Our Ref: 24/00871/HFUL  
Your Ref: 43 High street Over

### **South Cambridgeshire District Council Application for Planning Permission**

Proposal: First floor rear extension over existing house and single storey extension to outbuilding, following demolition of existing sheds and conservatory.

Site address: 43 High Street Over Cambridgeshire CB24 5NB

CLIENT:	Justin & Anita Piani
PROJECT:	43 HIGH STREET OVER CAMBS CB24 5NB
TITLE:	PROPOSED LAYOUTS & LOCATION PLAN
SCALE:	1:50@A1
DATE:	26.11.2024
DRAWN BY:	P.W.
CAD REF:	43HST-OV1-01c
DWG No.:	43HST-OV1-03A

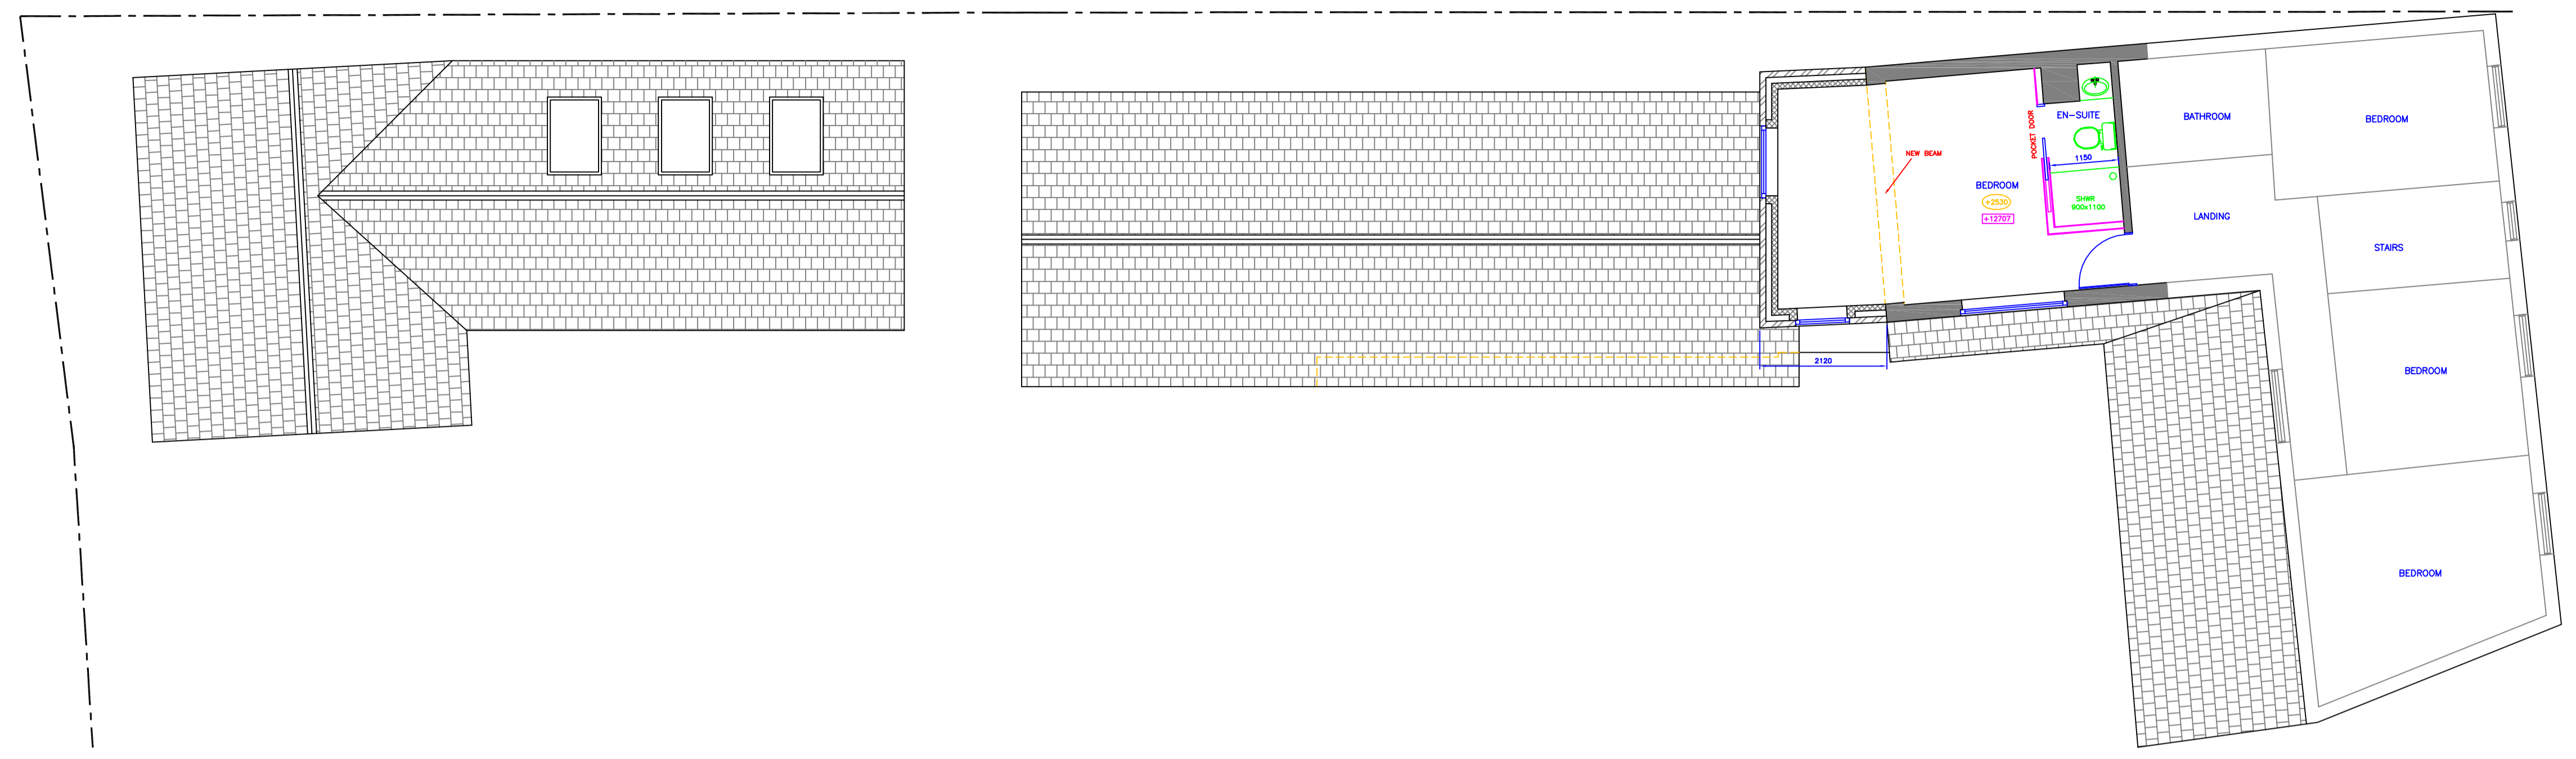
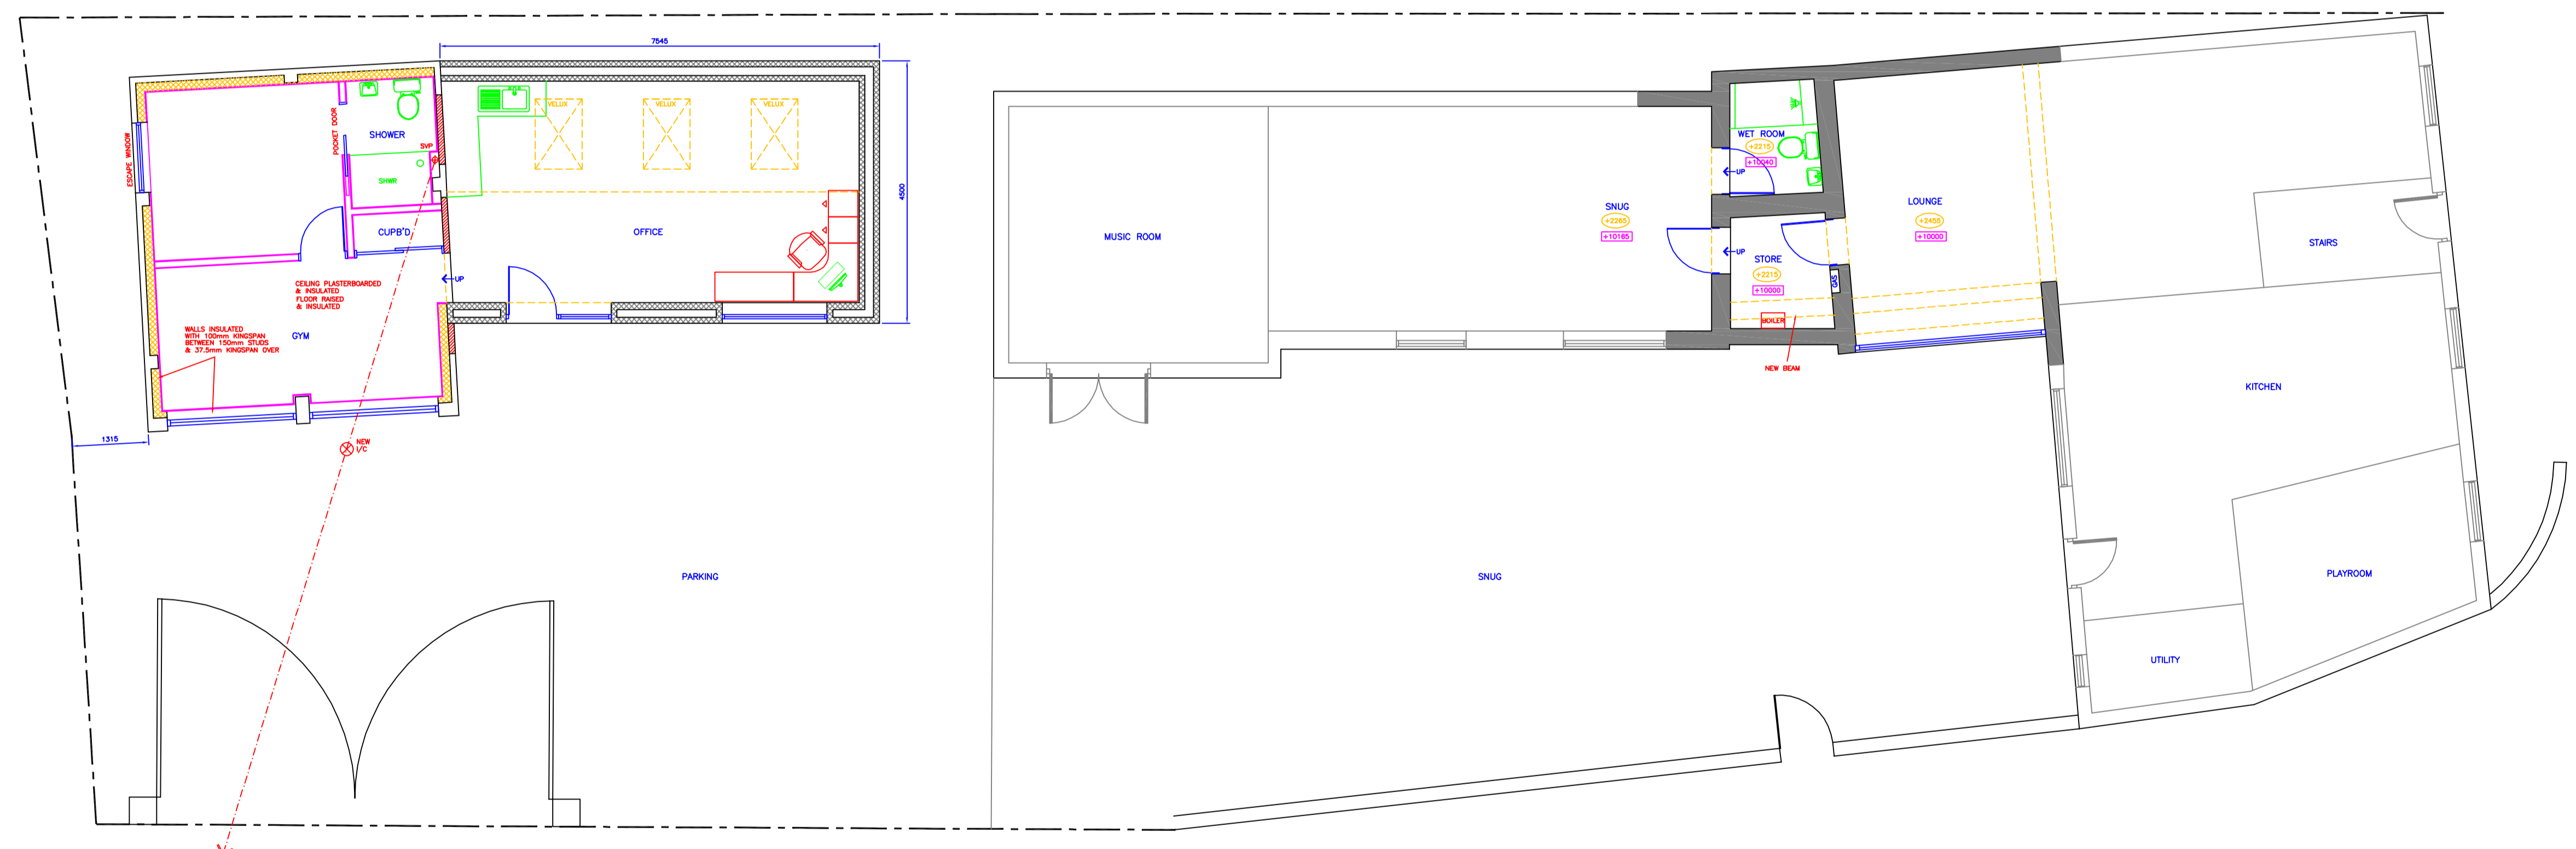
1. Please provide existing/proposed floorplans. Please ensure these are at a scale of 1:50/1:100 and show demolition of walls/buildings

As per planning officer advised please provide the existing/proposed floor plans for the entire house. The plans we have received only showing the partial existing floor plans.
